May 31, 2012

TO: Nelle Donaldson  
Barbara Barhydt  
FROM: David Margolis-Pineo Dept. of Public Services  
RE: Review Comments: 11 Pomeroy Street – Single Family Home

SHEET
1
REPRODUCTION OR REUSE OF THIS DOCUMENT WITHOUT THE EXPRESSED WRITTEN CONSENT OF BH2M INC. IS PROHIBITED

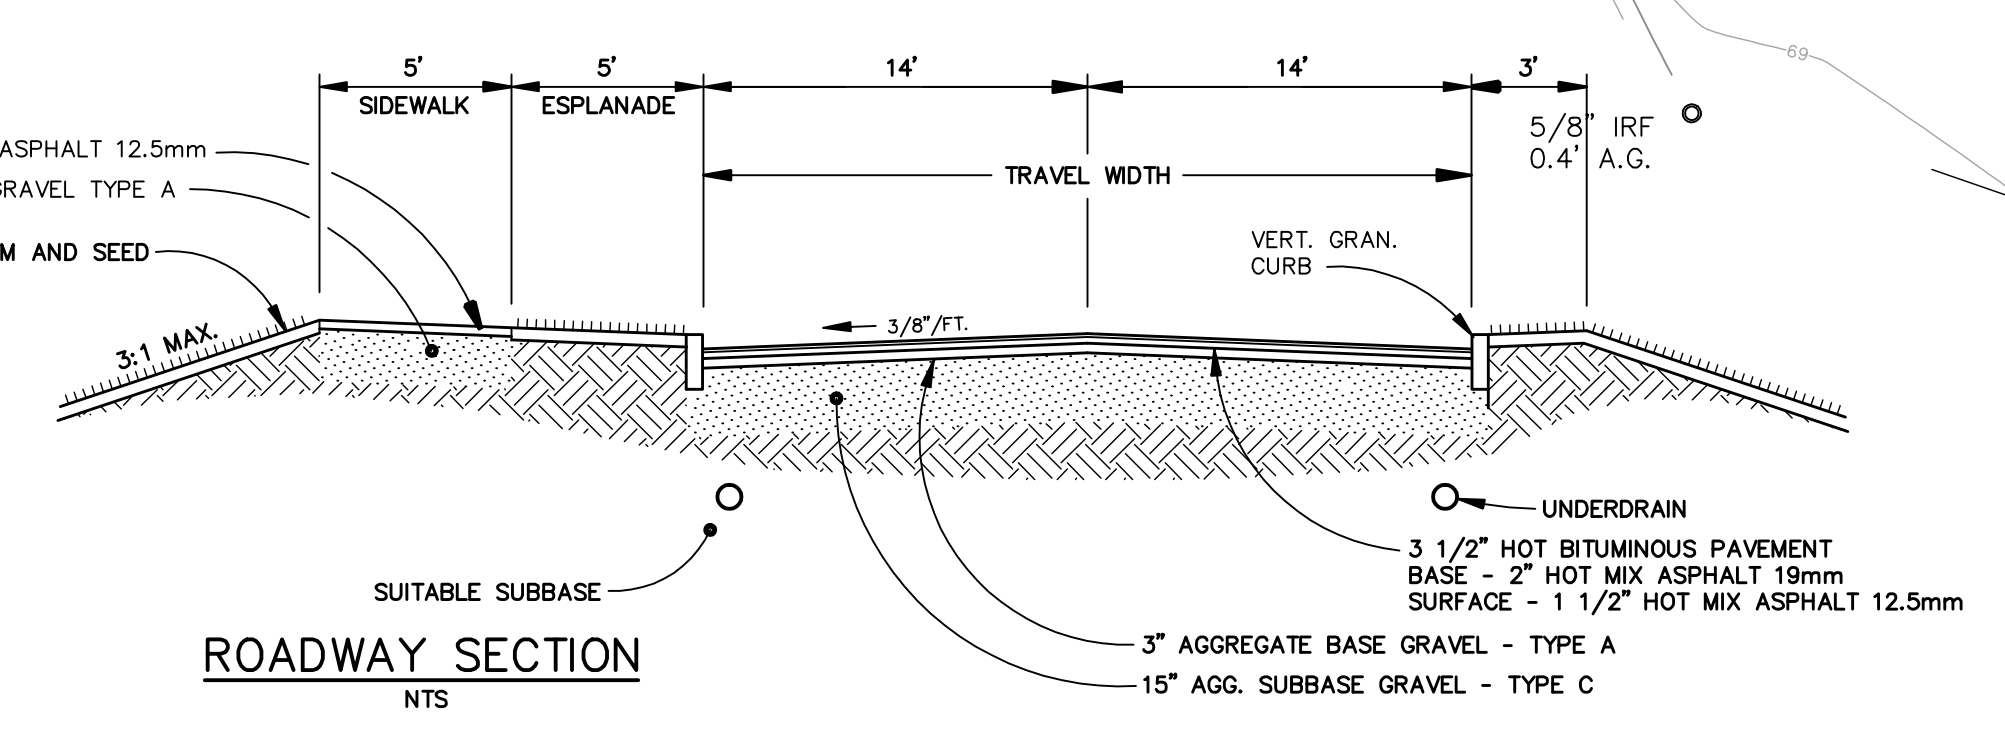
9. On Sheet 1 please indicate the status of the streets shown, i.e. accepted, vacated, paper, etc. A separate survey plan for acceptance is suggested.
10. Sheet 1 needs to be on the Maine State Plane for acceptance.

11. Sanitary manhole rim are not acceptable as an official city benchmark.
12. As shown, are drainage easement required? (Danielle)
13. Need to define the area of Pomeroy St. to be accepted with linework, bearings and distances and granite survey monuments.
